KITTITAS COUNTY COMMUNITY DEVELOPMENT SERVICES

August 14, 2025

RE: Shoreline Exemption Permit (SX-25-00013 Schwartz) – Deemed Incomplete – Request for Additional Information

SITE PLAN

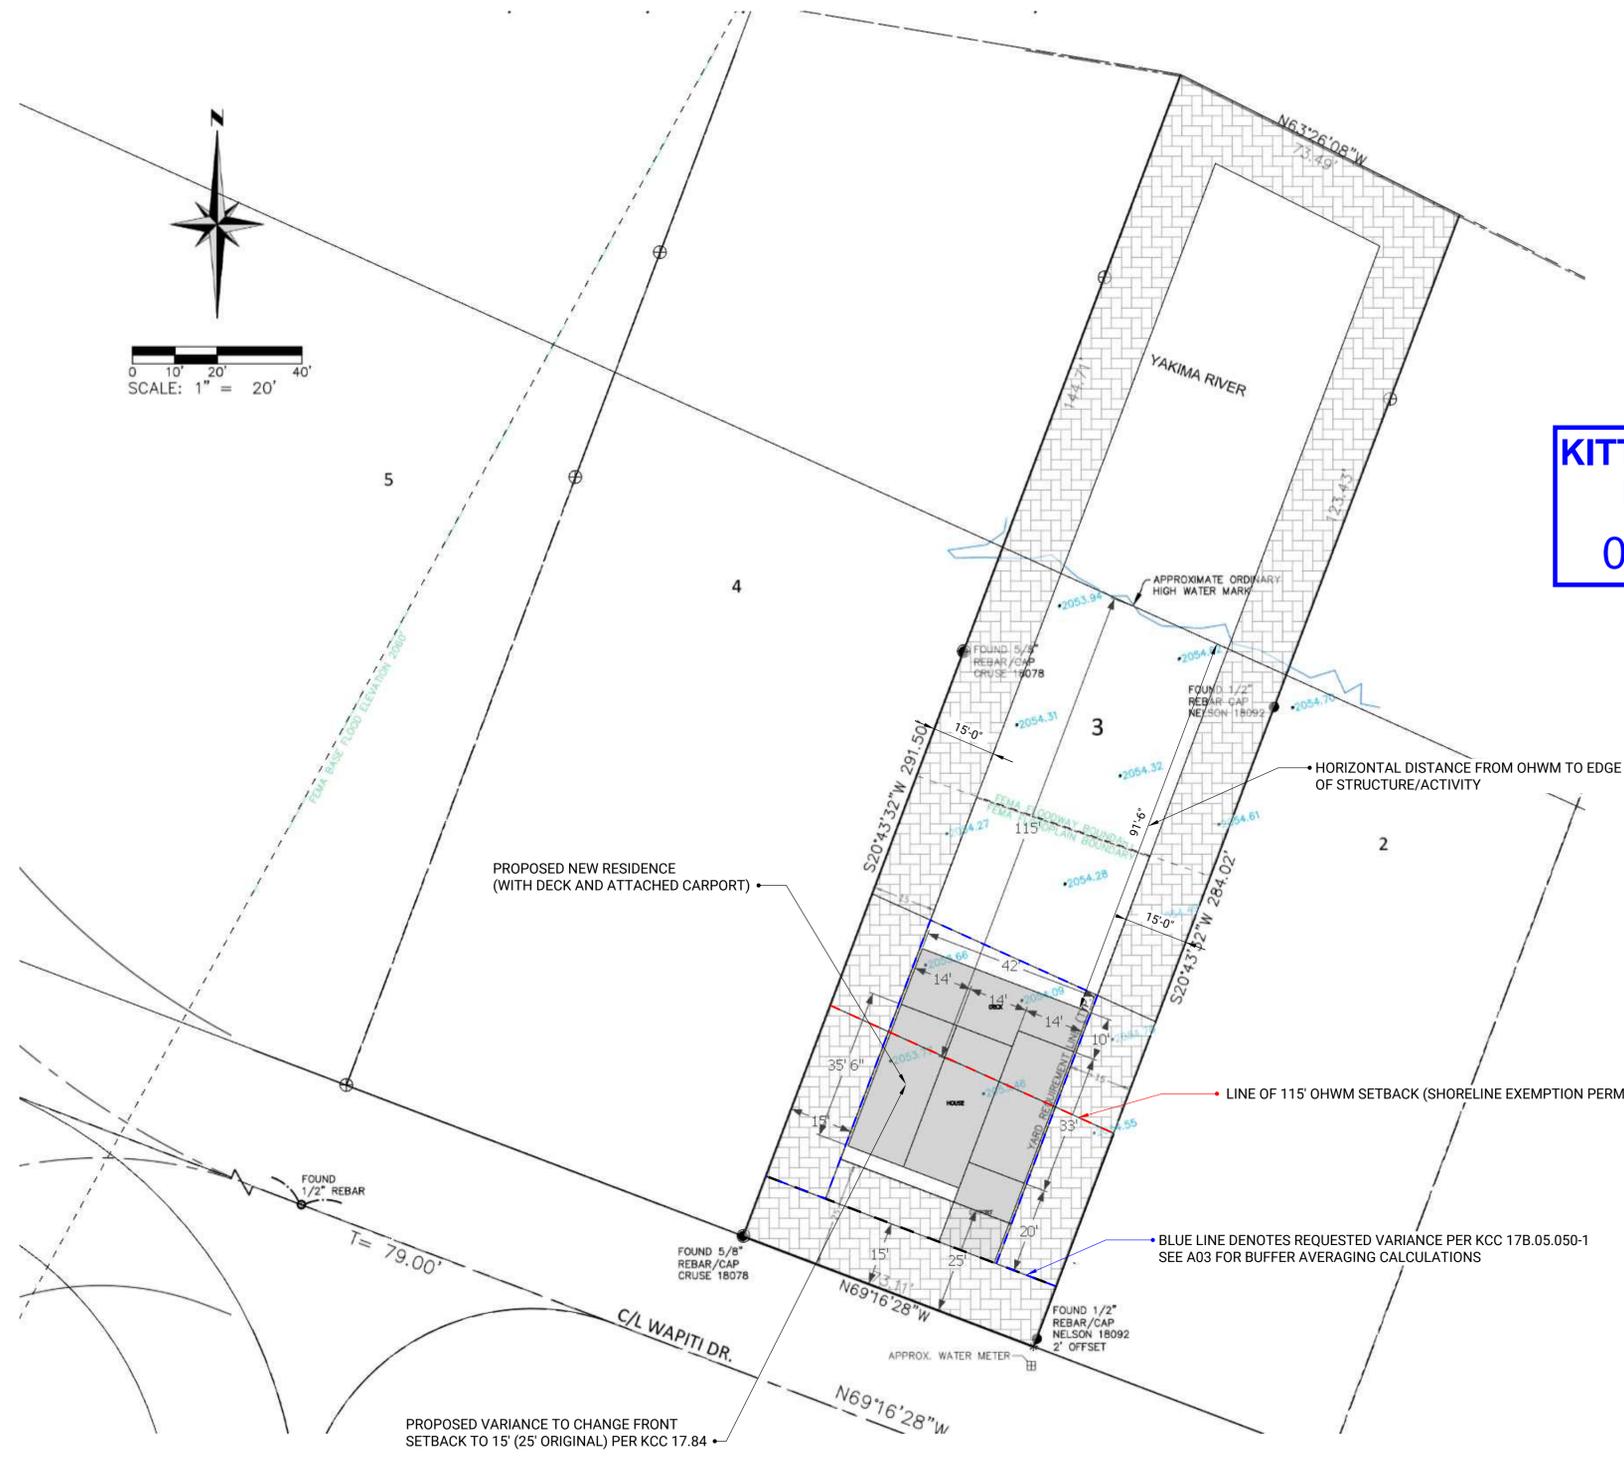
1. Please provide an updated site plan showing the exact location of all proposed structures, septic system components, drain fields, etc. In addition, please provide their dimensions, as well as each component's distances from property lines, rivers, and horizontal distances from the Ordinary High Water Mark (OHWM).
 - a. The site plan submitted with your On-Site Sewage System (OSS) application does not match the site plan provided with your shoreline exemption application. For CDS to process the shoreline exemption correctly, both applications must reference the same, consistent site plan.
2. Please submit a Critical Areas Report prepared by a qualified professional that meets the requirements outlined in KCC 17B.05.020(W).
3. Submit revised narrative that describes the project as shown on the site plan.
